Re Planning Application FP/274/18/PL

In summary, the detailed attachments discuss why I believe the planning application for two dwellings to be erected on the site at 10, Felpham Gardens should be rejected, justified on the basis outlined below, specifically including:

The attached document addresses key elements in submissions submitted by Rodway Planning Consultancy Ltd. (Rodway), Arbotrack Systems Ltd., and the Biodiversity Checklist in support of subject Planning Application to demolish an existing building at 10, Felpham Gardens, Felpham and construct two dwellings on the site.

EXISTING PLOT PLAN

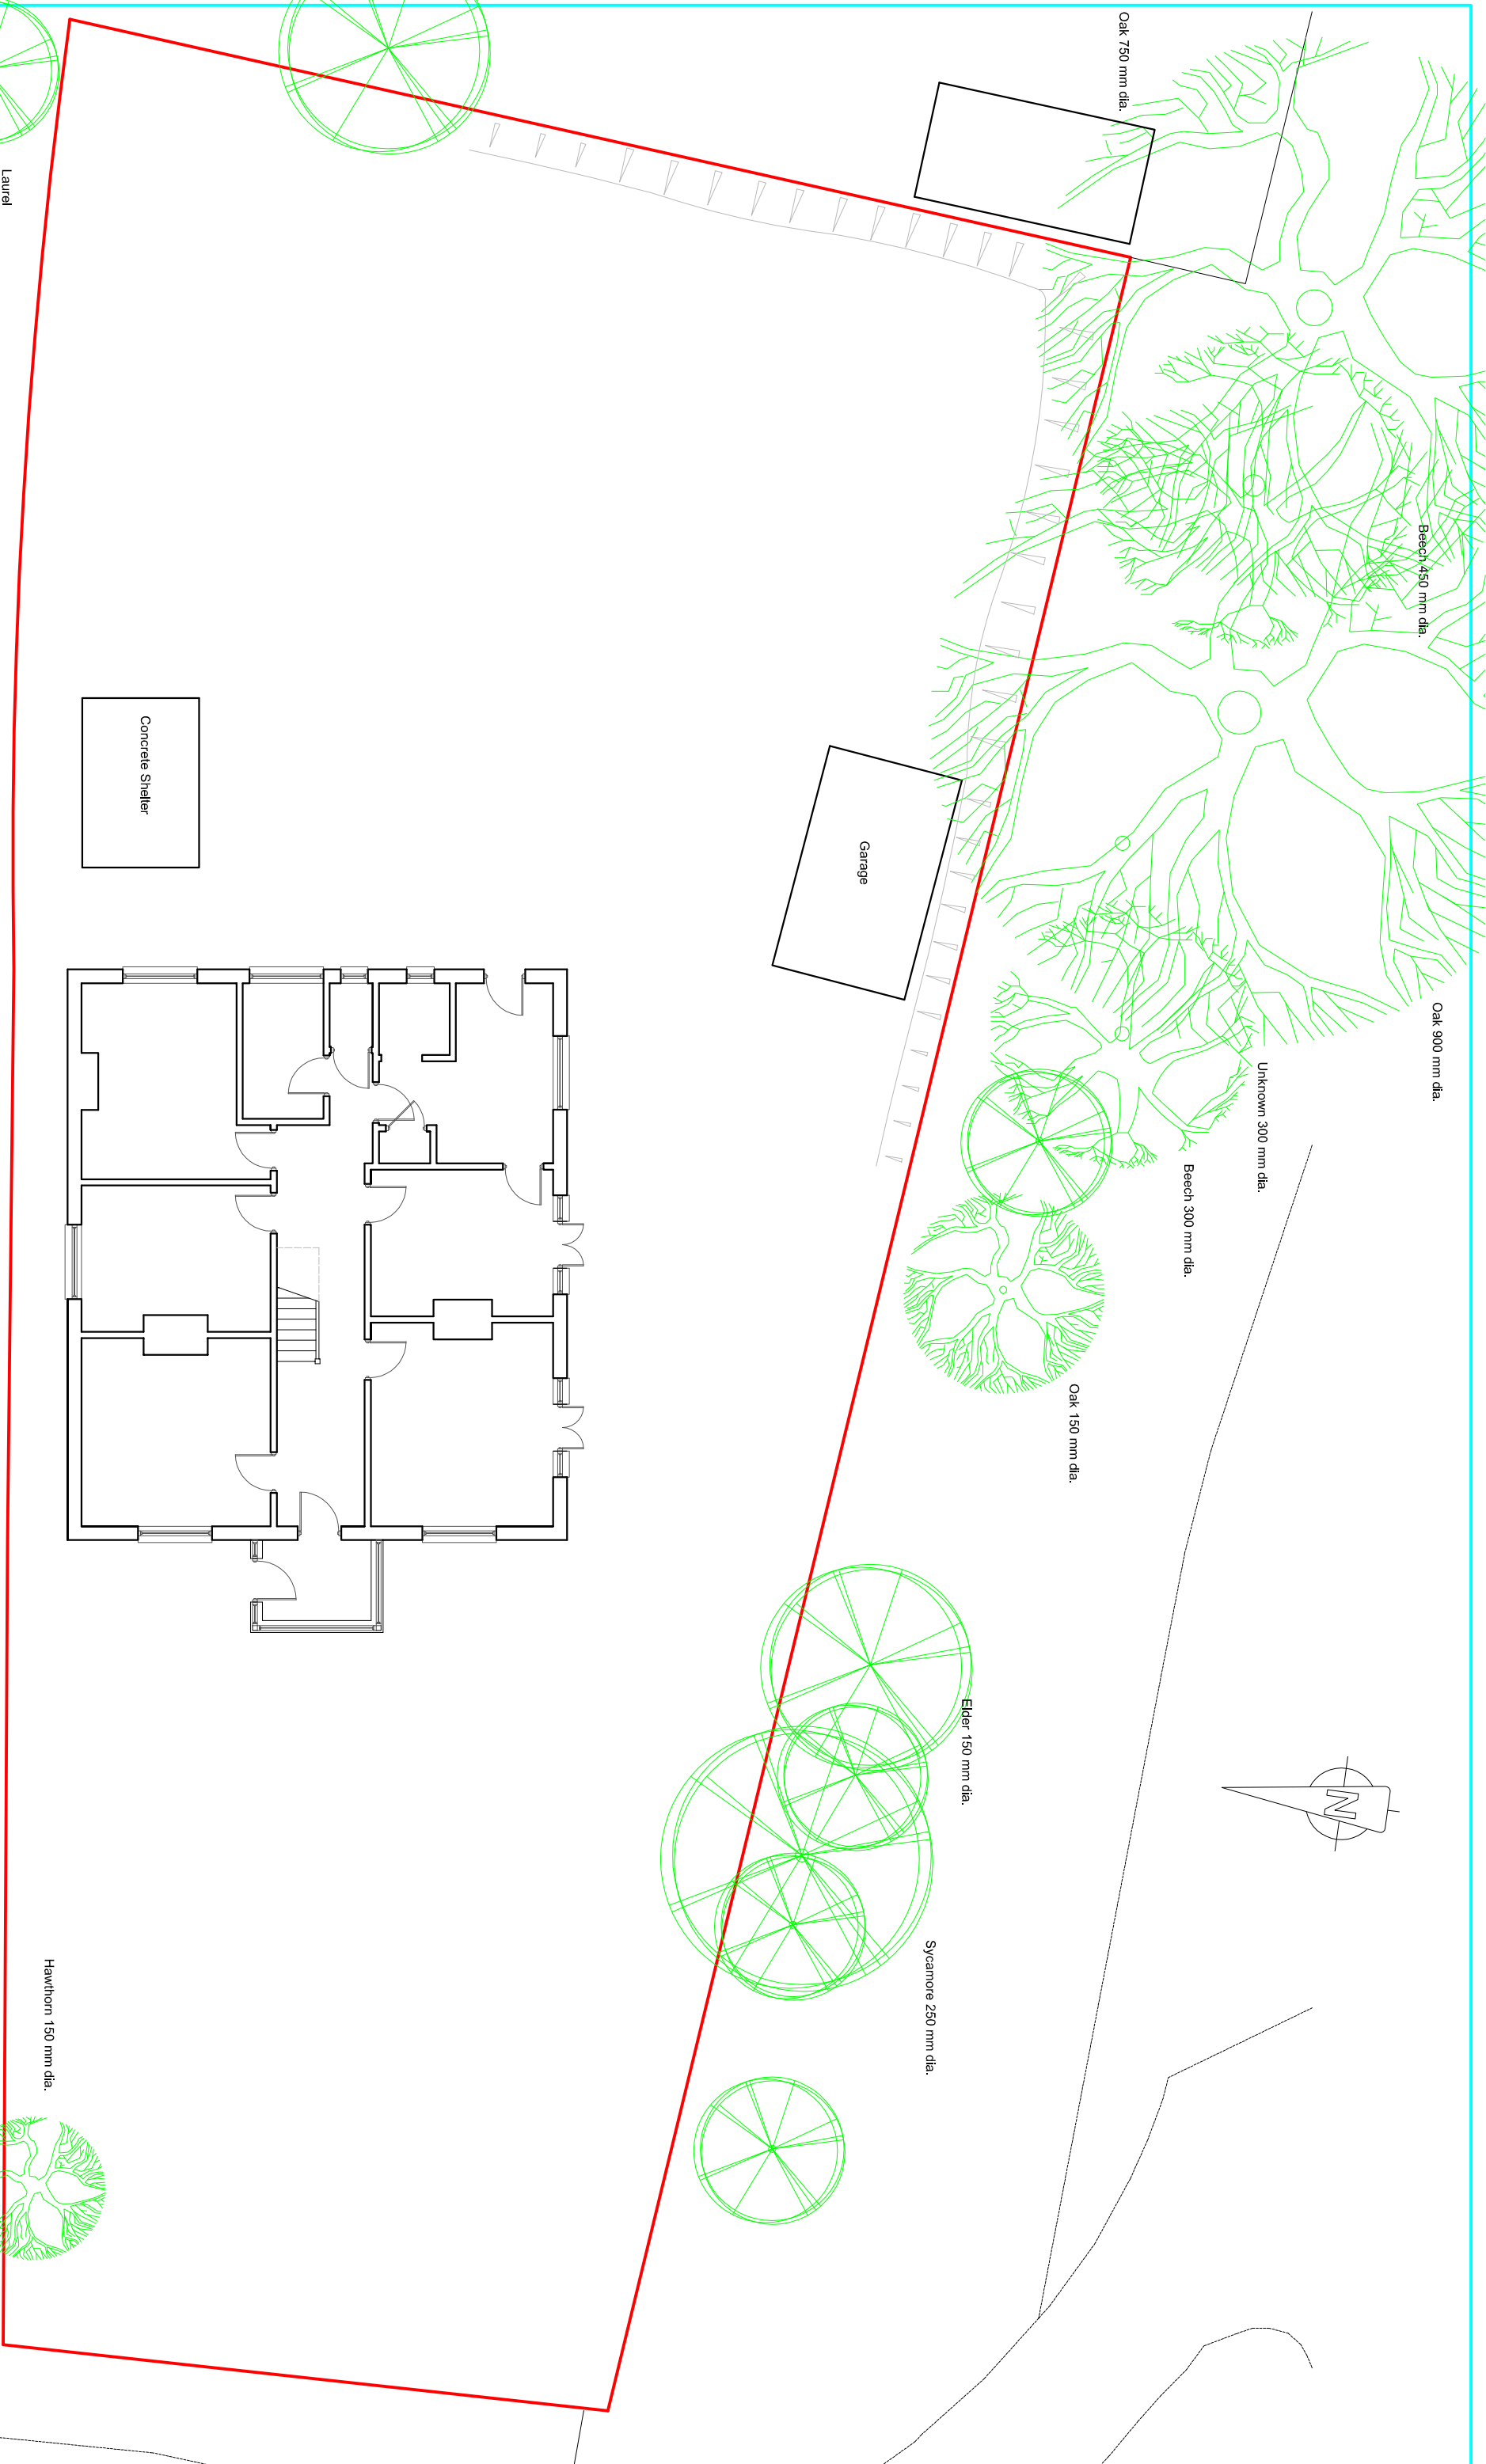
- ii. Submission of a planning application together with supporting documents – which fail to reference the previously removed trees.
- iii. Inaccurate outline plan of the site, specifically the proposed drive from the property at its junction with Felpham Gardens.

To maintain alignment with the frontage building line along Felpham Gardens - "marginally" is too loose a description and frequently disregarded in the building trade and, from the plan, it is clear that to enable the construction of two buildings on the plot, the front building line will have to be moved forward significantly from the current building line. In reality, to

ensure and maintain integrity of the building line, there should be no variance from the current building line along Felpham Gardens.

- i. The "Street View" drawing indicates one vehicle at the front (west) – with apparent space for another vehicle – but this paragraph apparently references 2 No. parking spaces to the front of the site, (somewhat unclear). Regardless, there is insufficient space for the "two car" parking slots, or even one, adjacent to the road without extending the dropped kerb across the proposed parking area and possible realignment of the current drive, where it aligns with exit onto Felpham Gardens.
- ii. This paragraph is contradicted by the contents of Paragraph 6.40 which states that 2 No. spaces are provided for each dwelling and an additional visitor space, which could in fact be a total of 6 No required parking spaces if the parking space/s shown on the drawing adjacent to the road are included.

The space identified will require an extension to the current dropped kerb – which may also require realignment to coincide with the proposed drive along the southern perimeter of the property. This paragraph contradicts Paragraph 3.6, and is further addressed in some detail in the “Comments” section of 3.6 above.
